CITY OF ALBUQUERQUE

RE: Coors and Central – 100 Coors Blvd NW
Conceptual Grading Plan
Engineer's Stamp Date: No Stamp Date
Hydrology File: K10D017

This letter is in response to your comments by letter dated December 11, 2017. The comments have been addressed as follows:

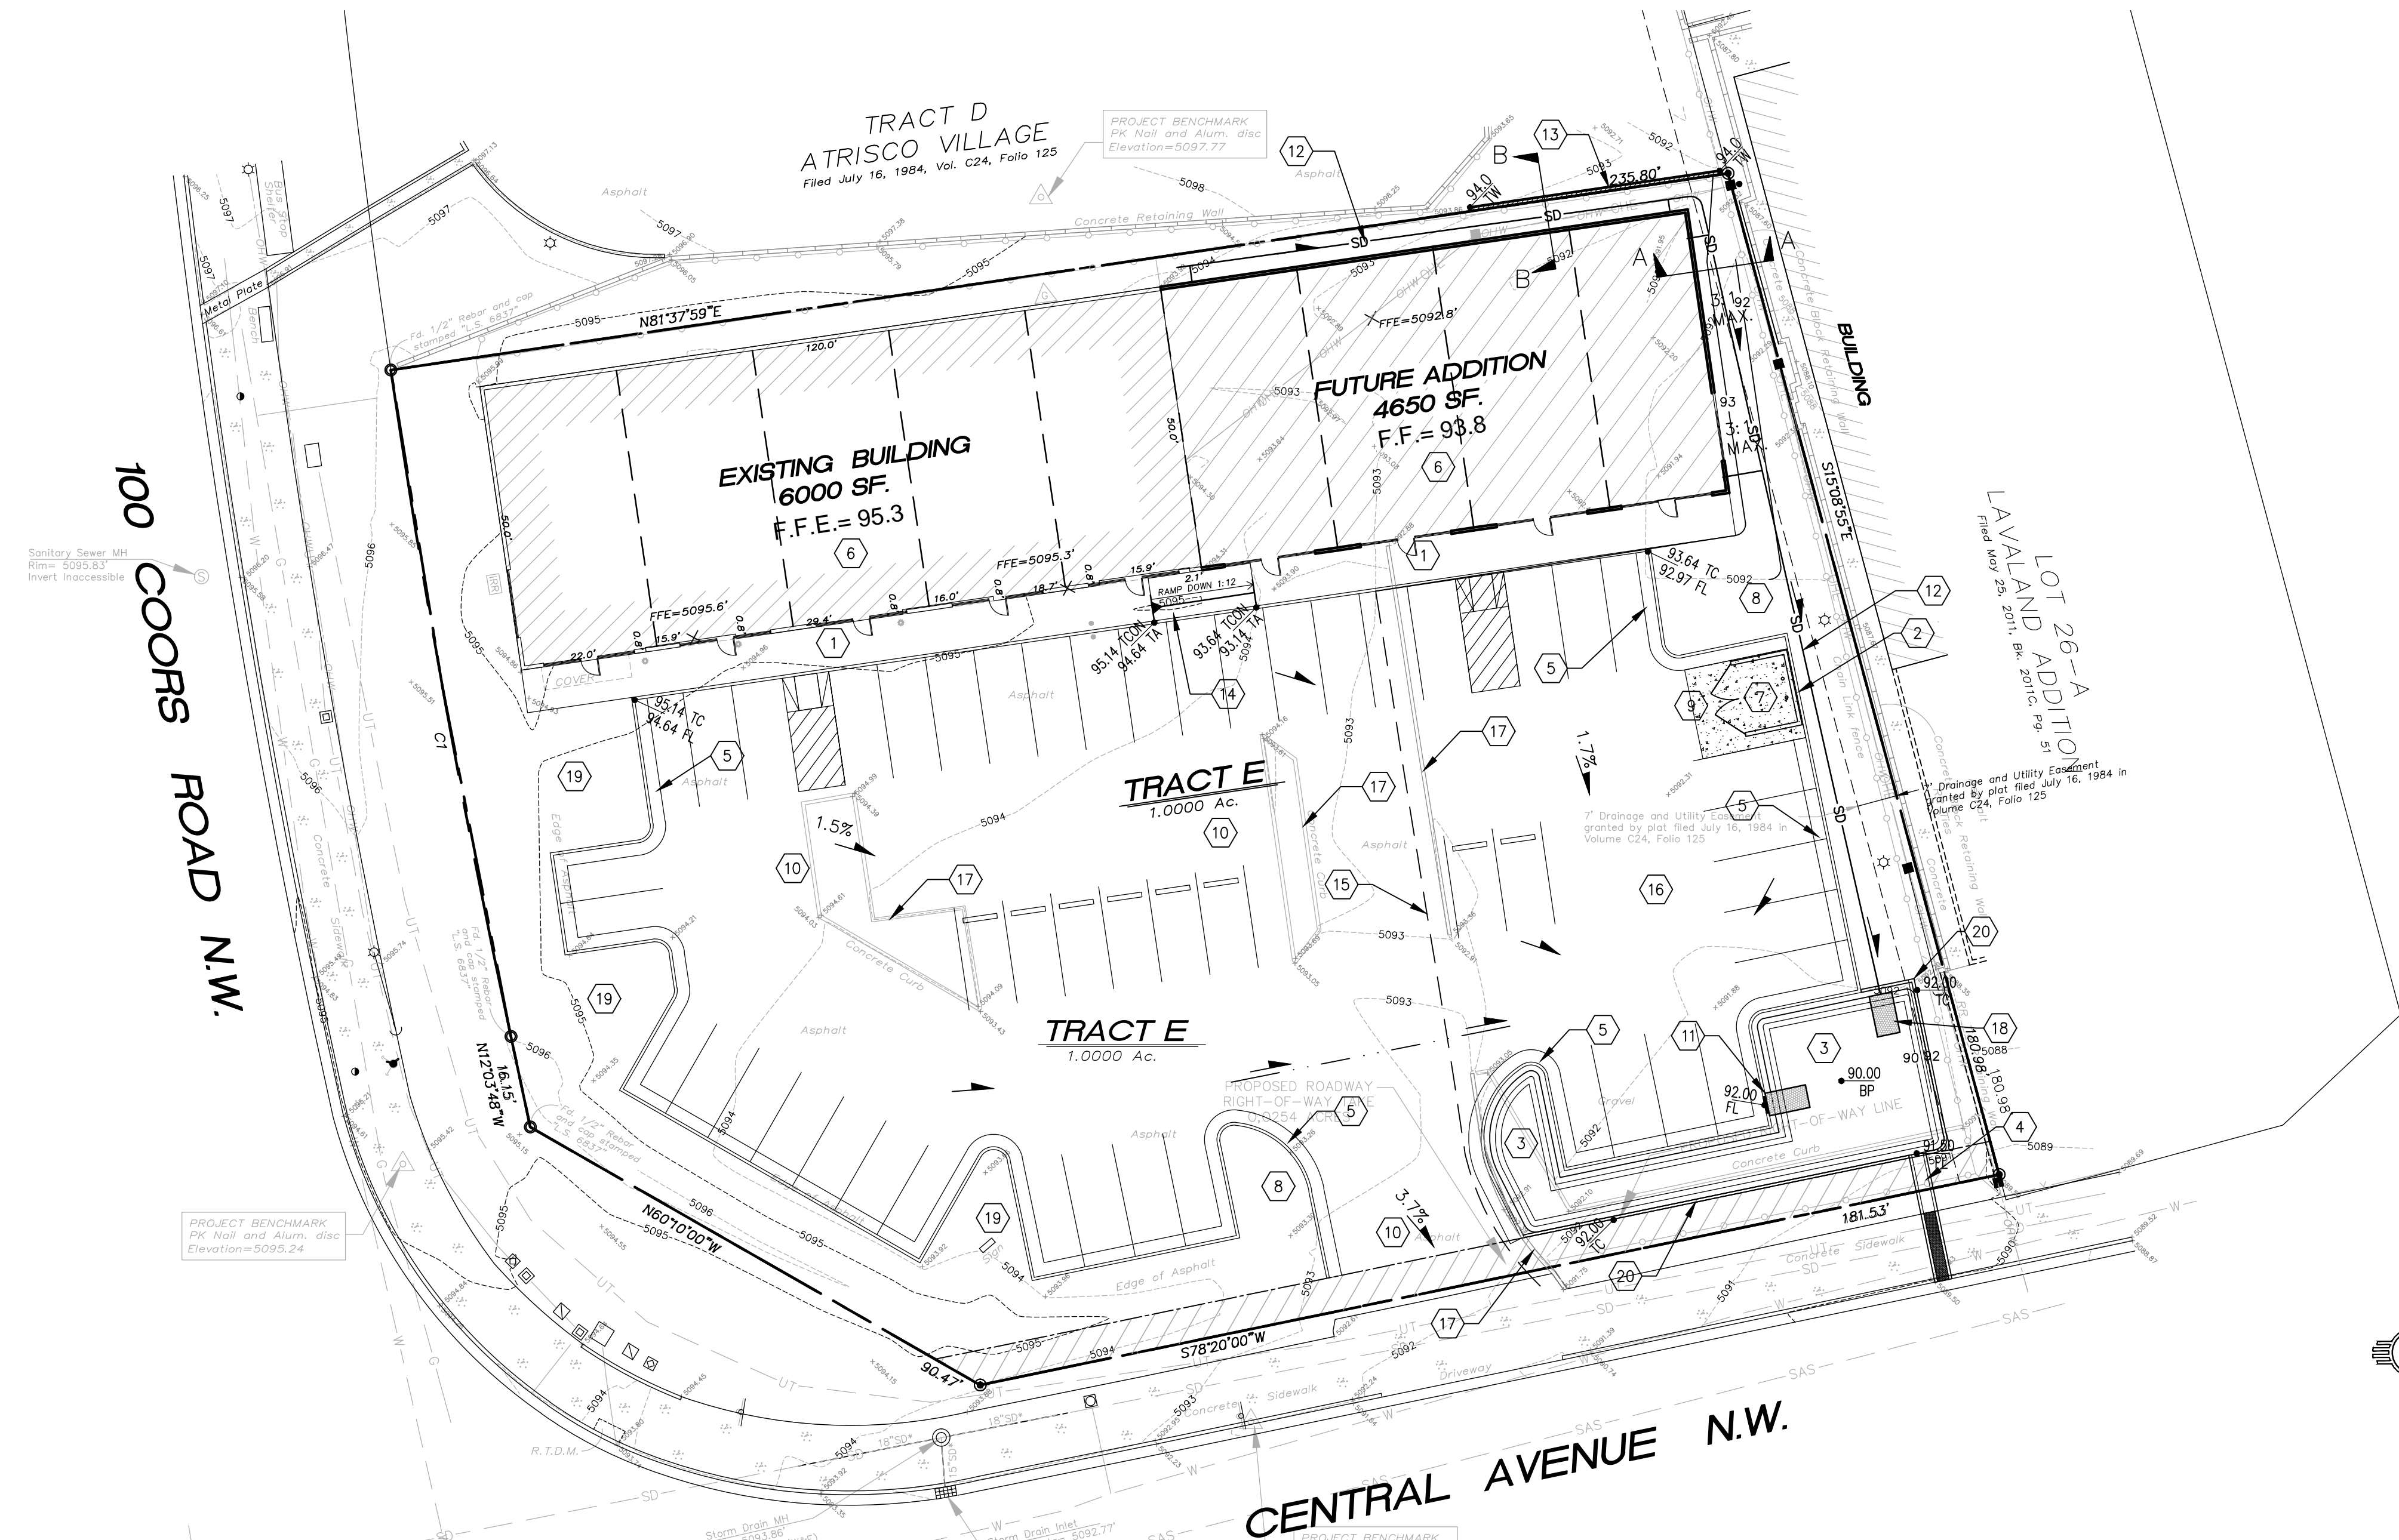
1. Please provide the FIRM Map and flood plain note with effective date.

2. Please provide a vicinity map showing the location of the site. Typically this is the Zone Atlas. This can be downloaded in pdf format from the City of Albuquerque's website.

3. Please add the property line in both Section A-A and Section B-B.

4. Please also show the retaining wall footer in both Section A-A and Section B-B.

5. Per DPM Ch. 22.5B, grading and construction of retaining walls at or near the property line must demonstrate that the adjacent property is not damaged or its use constrained. Any such encroachment by the wall or grading must be accompanied by written permission of both landowners.

6. Per Transportation's DRB comments on December 6, 2017, the overall site plan will have some changes and some will affect the drainage. Please insure that the Conceptual Grading Plan matches the Site Plan for Building Permit.

See attached Conceptual Grading and Drainage Plan.

See attached Conceptual Grading and Drainage plan.

See attached Conceptual Grading and Drainage plan.

See attached Conceptual Grading and Drainage Plan.

Section B-B is the only section with a new retaining wall. Section A-A the wall shown is an existing retaining wall. The retaining wall on the north property line is placed so that the entire wall and footing is within the property line, as seen in section B-B on Conceptual Grading and Drainage Plan attached.

The Architect met with Raquel from Transportation and all of the site plan changes required by Transportation are contained on the revised Conceptual Grading and Drainage Plan attached.
